From: Jason Davies [REDACTED]
Sent: 26 August 2021 15:37
To: Amber Willard
Subject: Re: 55 Fitzalan Road, Arundel (AB/88/12/HH)

Proposed Extension and Loft Conversion
at 55 Fitzalan Road, Arundel
for Mr R Dowson & Ms S Harnett
Drawing P02 June 2021 Scale 1:100 / 1:500 @ A3
Planning Drawing - Roof Plan, Elevations & Block Plan

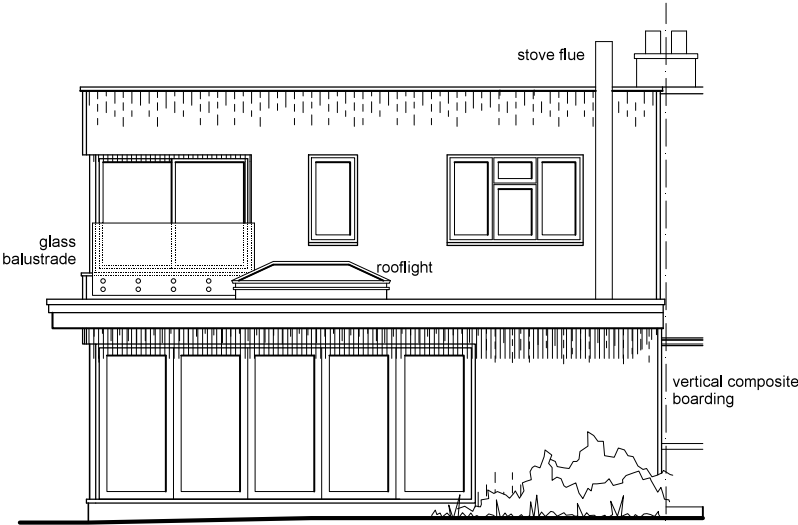
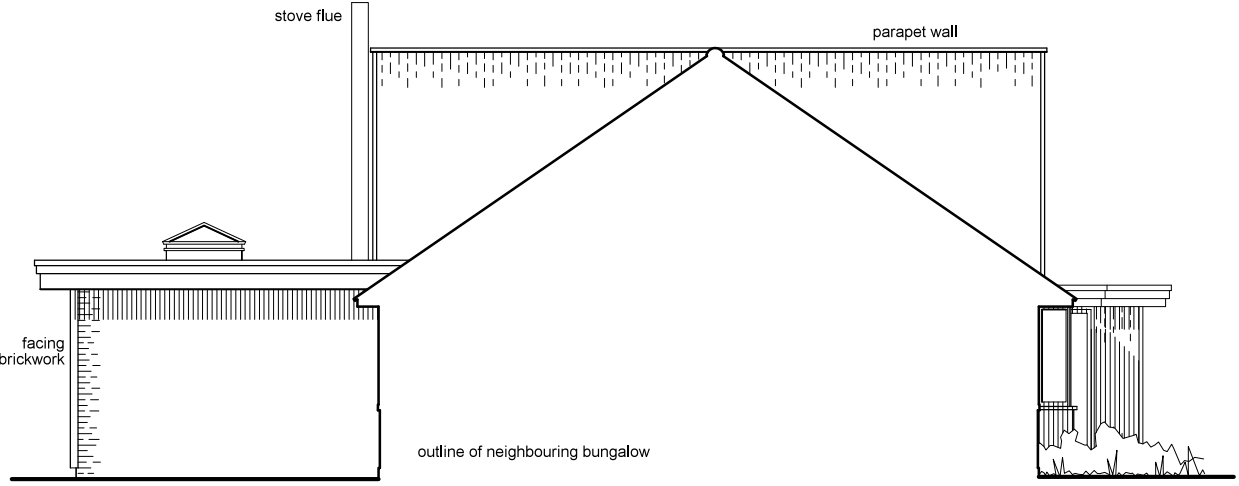
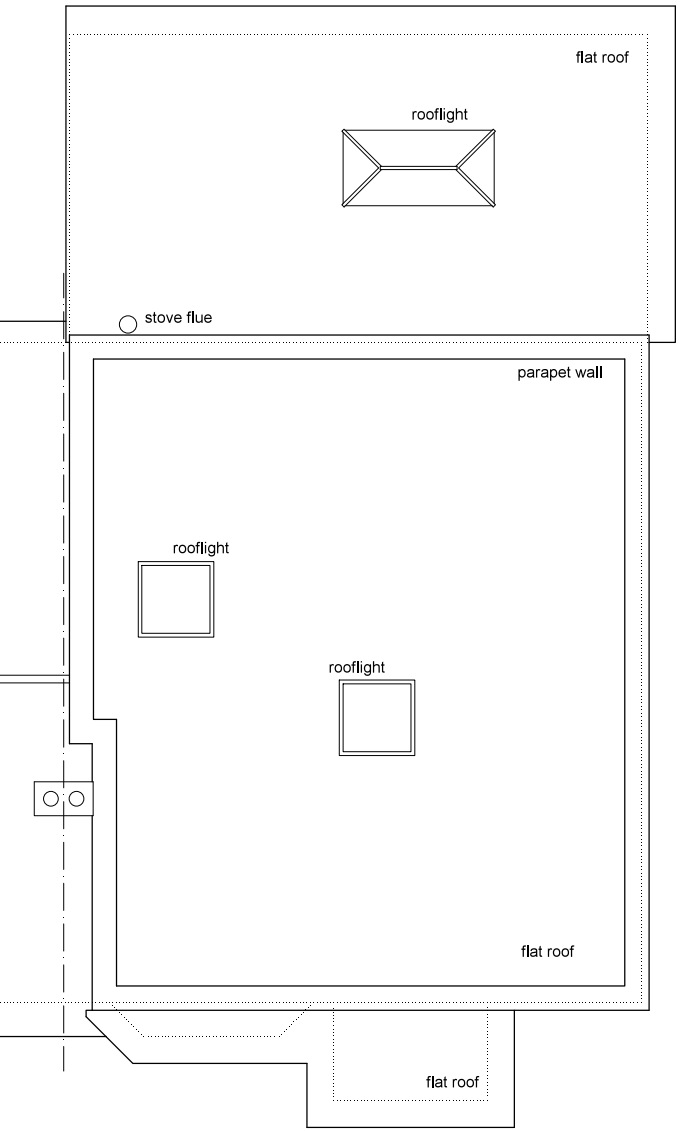
Upon discussing the application with my manager, unfortunately it will be refused, due to appearing out of character with the surrounding area which features predominately single storey bungalows.

I note there are front and rear dormers to the nearby properties which would be more acceptable.
